Re: Byron Shire Council submission - Cultural Events Site - State significant Development Application (SSD 8169)

Waste Water Assessment

Management and Restrictions to limit the expansion of the Events Site

Figure 2 Proposed wastewater management

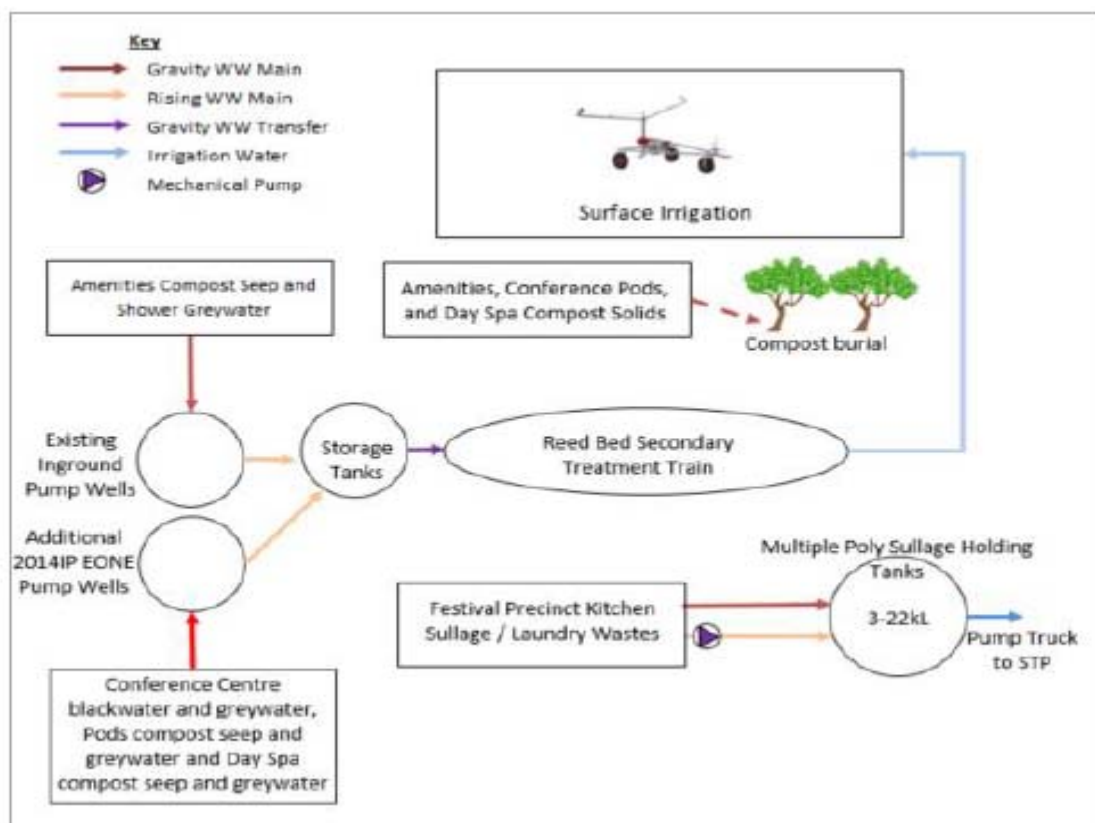
1. Very low wastewater generation rates;
2. Staged upgrade of OSMS as budgeting allows;
3. Continued burial of human compost on site;
4. Nutrient build up on dispersal areas over time;
5. The use of flood prone area for the surface spray irrigation of treated effluent via the incorporation of a complicated and integrated system of sensors, pumps, timers etc.; and
6. Continued transportation of kitchen festival sullage (trade waste) to Byron and Ballina STP (544k/L annum).

Whilst reference is made to a meeting between the applicant and Byron Shire Council's General Manager and Infrastructure Manager regarding acceptance of kitchen sullage there is no confirmation of acceptance by Council's Infrastructure services nor is there any verification from Ballina Shire Council that they will accept effluent from the development. These remain issues that need to be addressed by the applicant in either demonstrating how they comply with Clause 45 Provision of Services of Byron LEP 1988 or Clause 6.6 Essential Services of Byron LEP 2014.

The resultant Onsite Sewage Management System to accommodate up to the maximum of 50,000 patrons plus 5,750 staff for a single event requires a significant initial and ongoing commitment in resources, system design, management, operational/ qualified expertise, maintenance, monitoring, co-ordination, liaison, quality assurance, auditing and reporting to be successful. It is understood the Department had or were engaging GHD to provide expert advice in relation to the above. Council would be happy to meet with those experts at a latter time to discuss if required.
